Board Direction
BD-015963-24
ABP-313331-22

The Board decided to refuse permission, generally in accordance with the Inspector's recommendation, for the following reasons and considerations.

PLAN VIEW – PROPOSED LEFT IN LEFT OUT JUNCTION  
SCALE 1:250

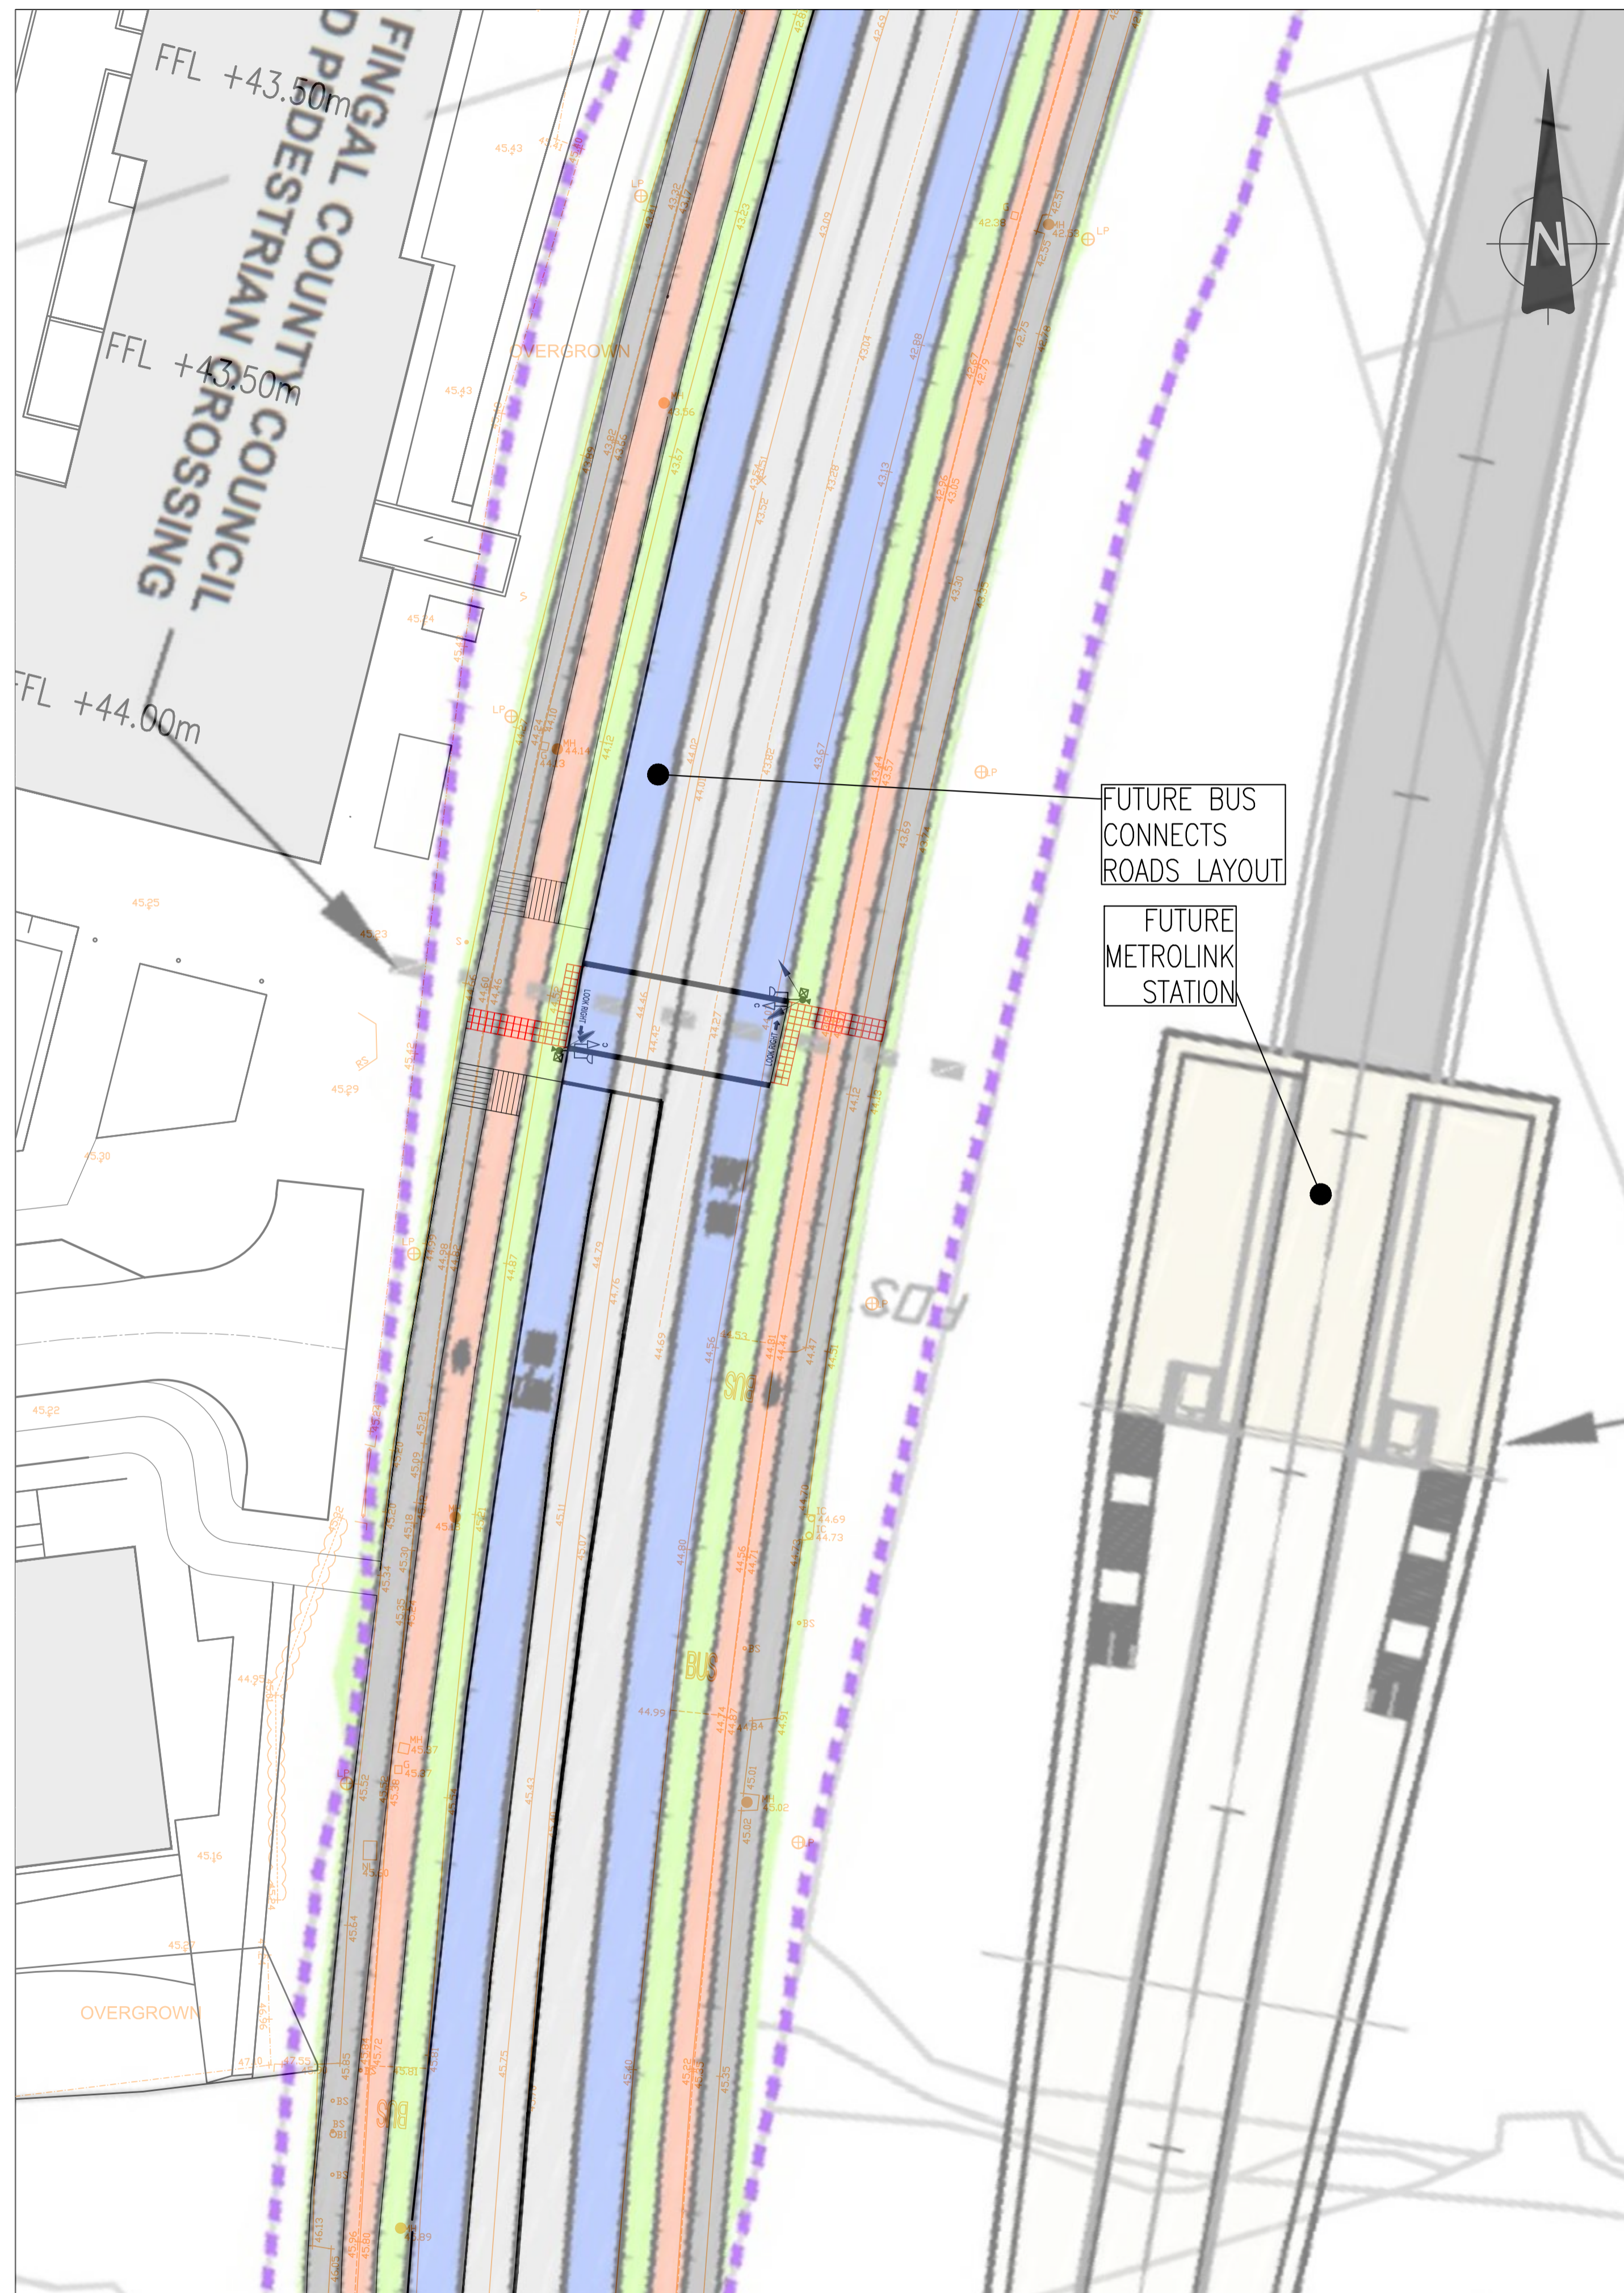
2. The proposed 'left-in, left-out' access/egress arrangements would give rise to significant negative impacts on the operation of the R132, in terms of road safety, and may conflict with the future operation of the Bus Connects Swords Core Bus Corridor. As such, the proposal is premature pending the delivery of the Fosterstown Link Road, which is a stated roads objective of the Fingal Development Plan 2023-2029 (Table 6.3 and CM041), and which will facilitate an appropriate access route to this site. The development as proposed would, therefore, endanger public safety by reason of traffic hazard and may prejudice the efficient operation of planned strategic infrastructure projects.

The second reason for refusal is traffic hazard. The movements generated by the proposed development would endanger public safety and would, therefore, negatively impact on the operation of the R132. The policy context regarding future access to these lands has not changed since the application was lodged. The Fosterstown Link Road was an objective in the previous County Development Plan and is an objective in the current Plan; the proposed development would, therefore, be premature pending the construction of this road.
